An
Bord
Pleanála

ABP-312606-22

Re: Recommendation to request further information for s.37E application ABP-312606-22

An application has been made by Ballinagree Wind DAC under the provisions of section 37E of the Planning and Development Act 2000, as amended, for the development of a wind farm development of 20 turbines with 110kV electrical substation and all related site works and ancillary development in the townlands of Annagannihy, Aughinida, Ballynagree East, Ballynagree West, Bawnmore, Caherbaroul, Carrigagulla, Carrigduff, Clonavrick, Derryroe, Drishane More, Dromagh, Drominahilla, Dromskehy and other townlands, Co. Cork.

PROJECT	CLIENT		
BALLINAGREE WIND FARM	BALLINAGREE WIND DAC		
SHEET	Date	15.12.21	Project number
	Drawn by	NS	P2114
	Checked by	TB	Drawing Number
PROPOSED WATERCOURSE CROSSING DETAIL - WF-HF8		P2114-0300-0017	
		Scale (@ A1-) AS SHOWN	Rev B

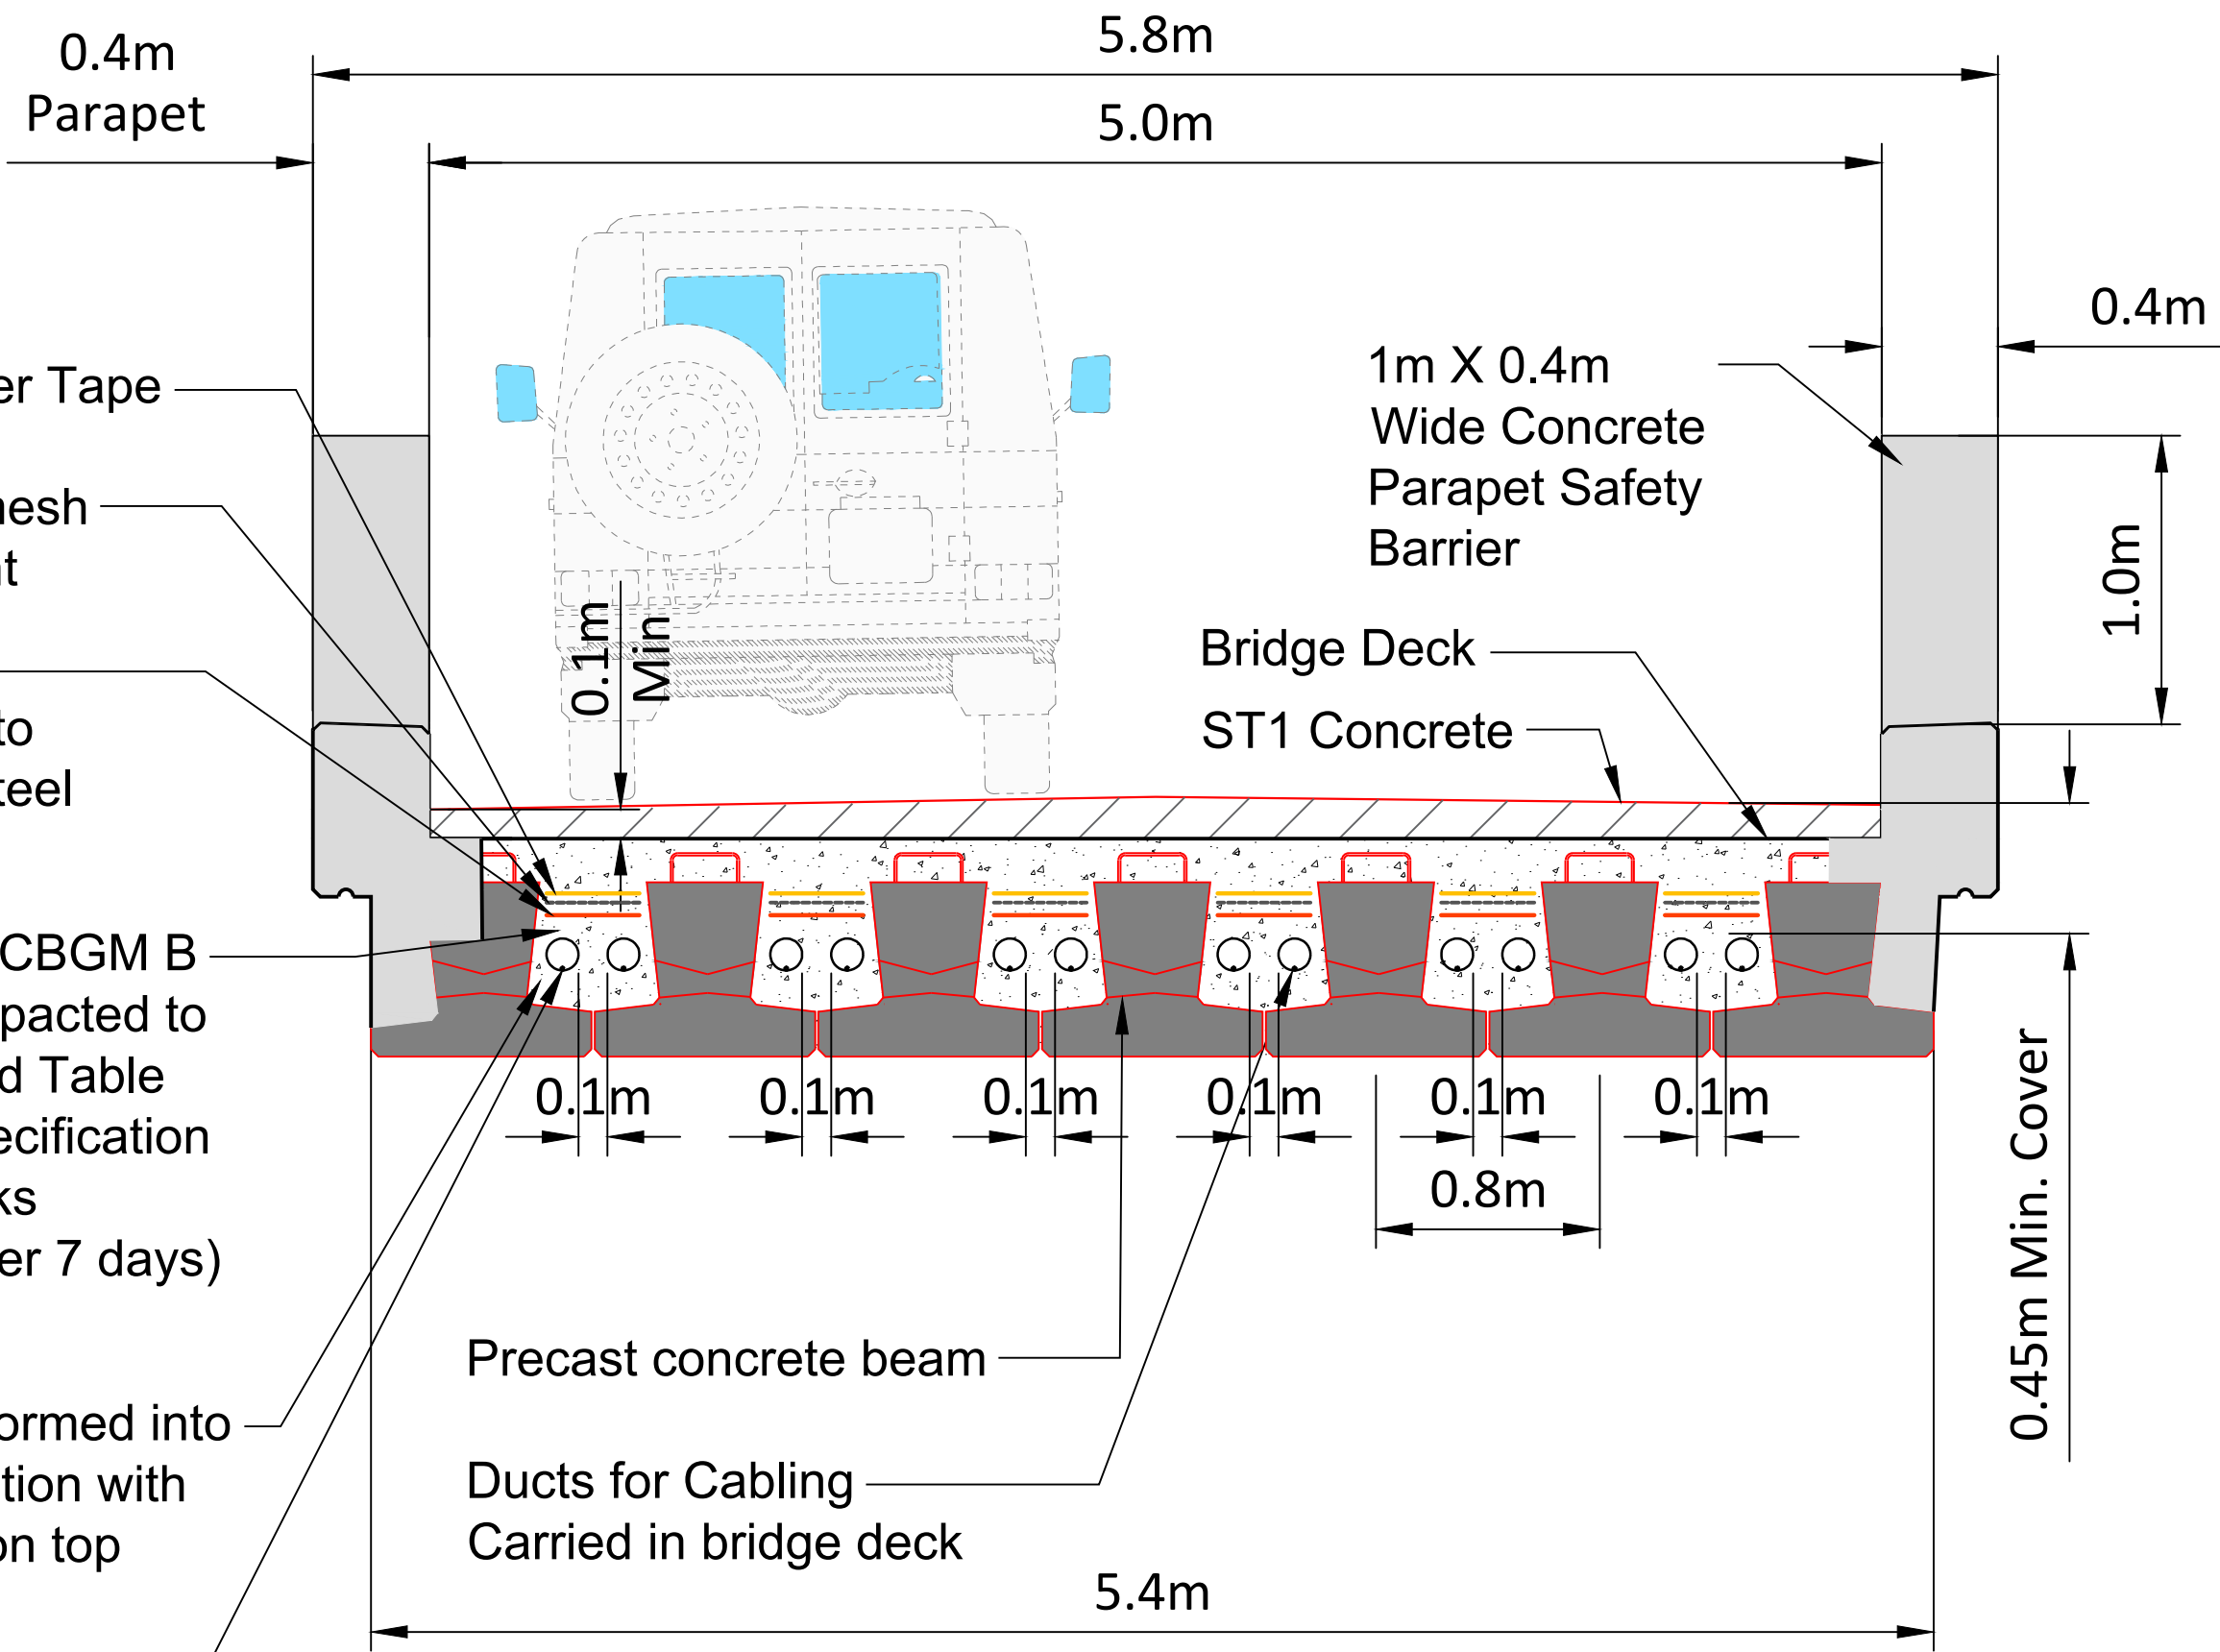
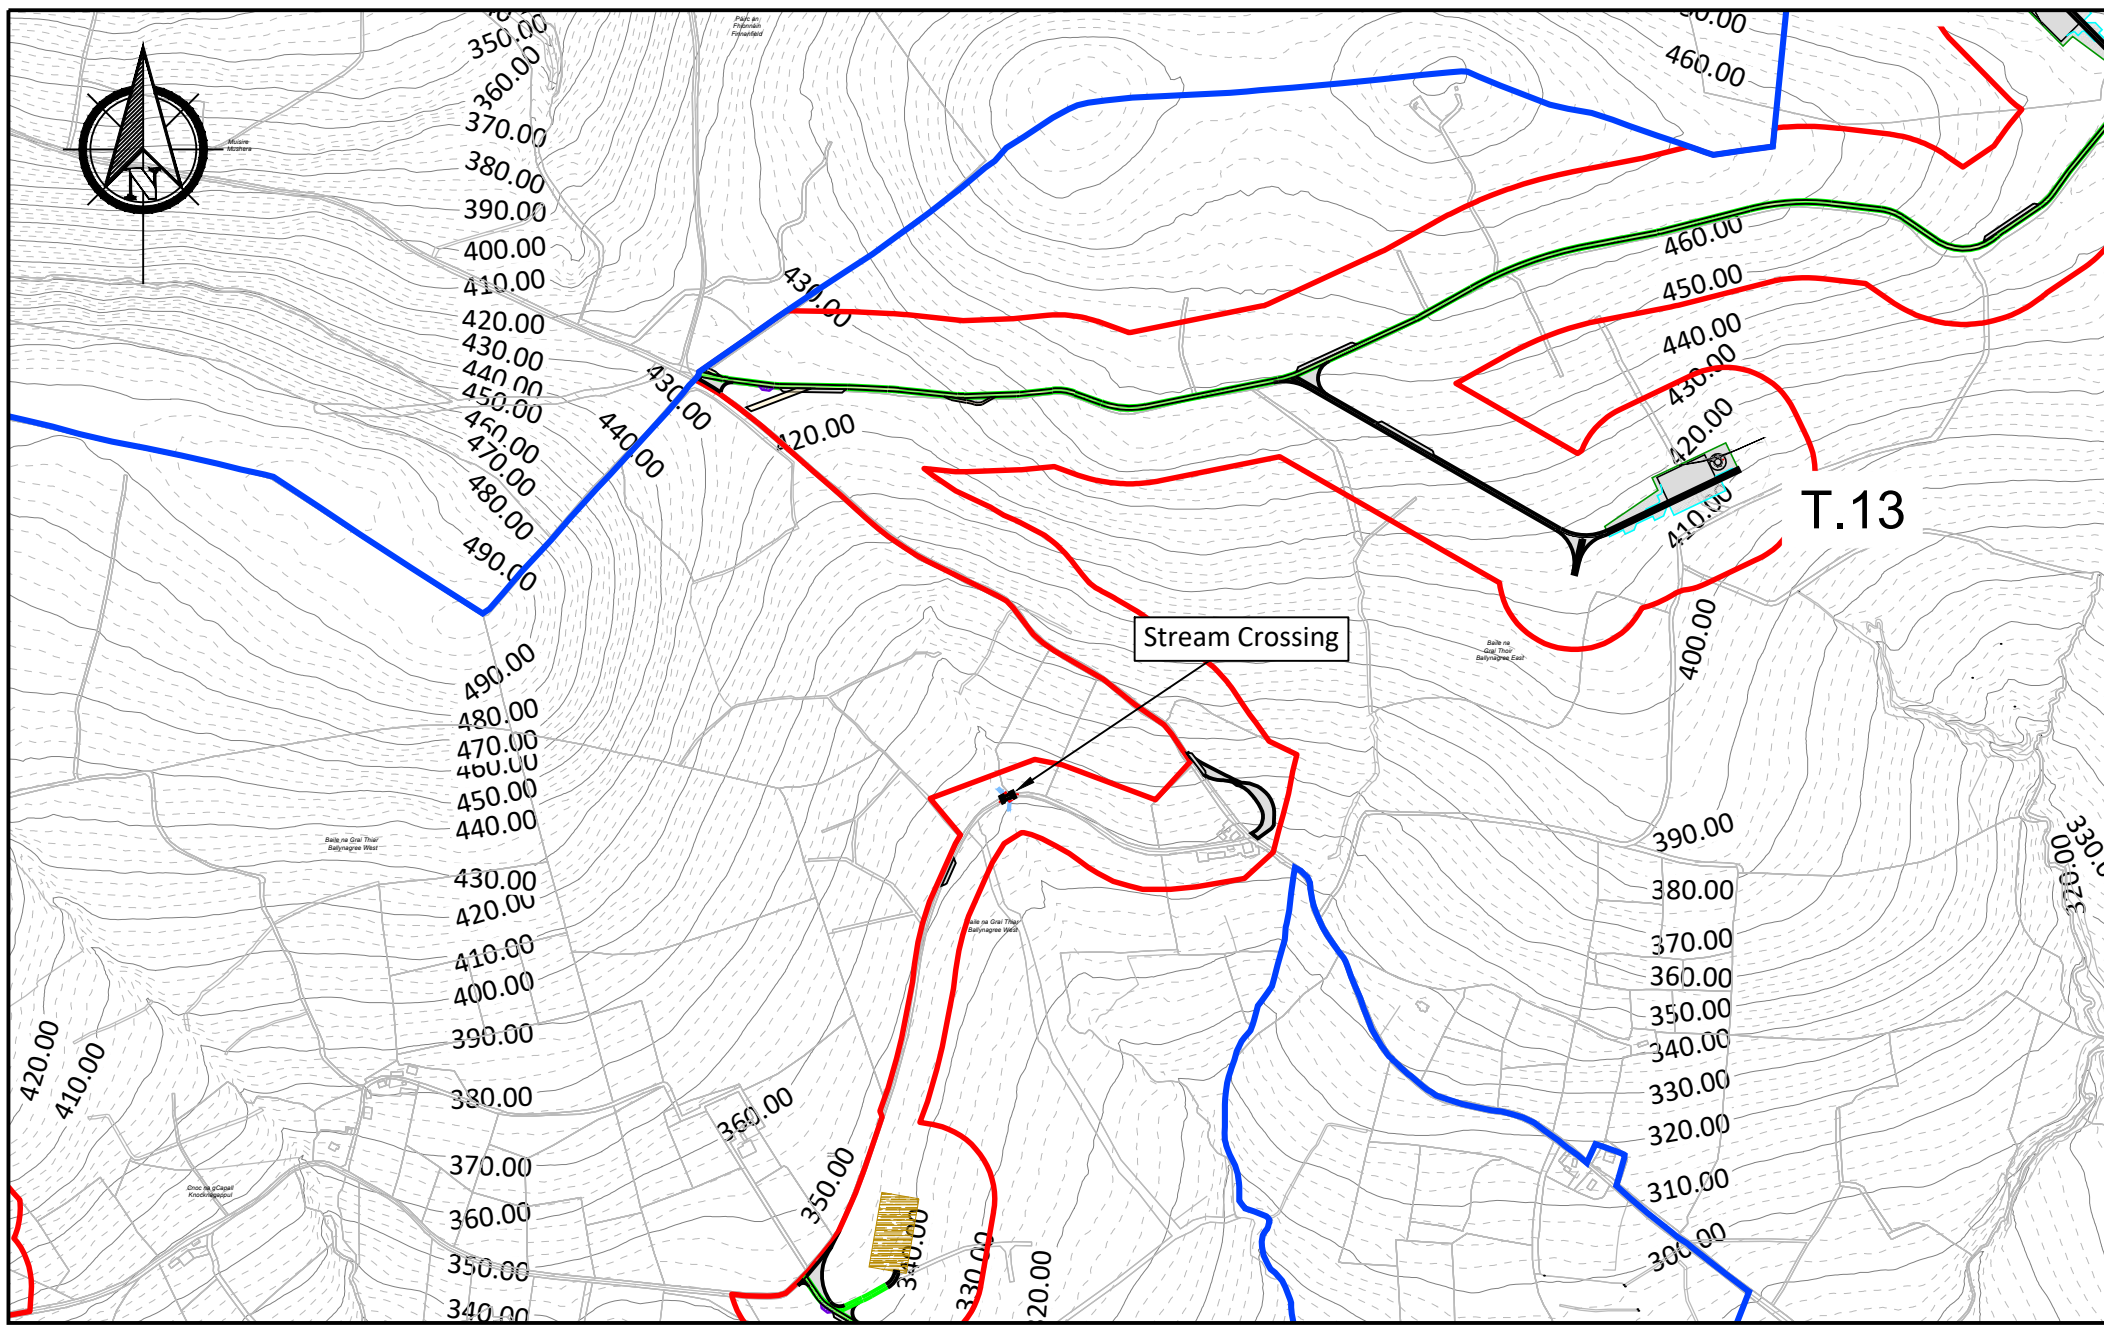
- WF-HF8: This structure appears to be located at a bend in the watercourse. The structure and bank should be designed to be safe against scour and erosion. This applies to all crossings for which section 50 consent is required.

- (d) Confirm whether the design of watercourse crossings WF-HF5 and WF-HF8 complies with OPW requirements.
- (iv) You are requested to provide a detailed response to the matters raised in the submission made by Cork County Council. In particular, this should include a response to the list of items contained in Appendix B of said submission.
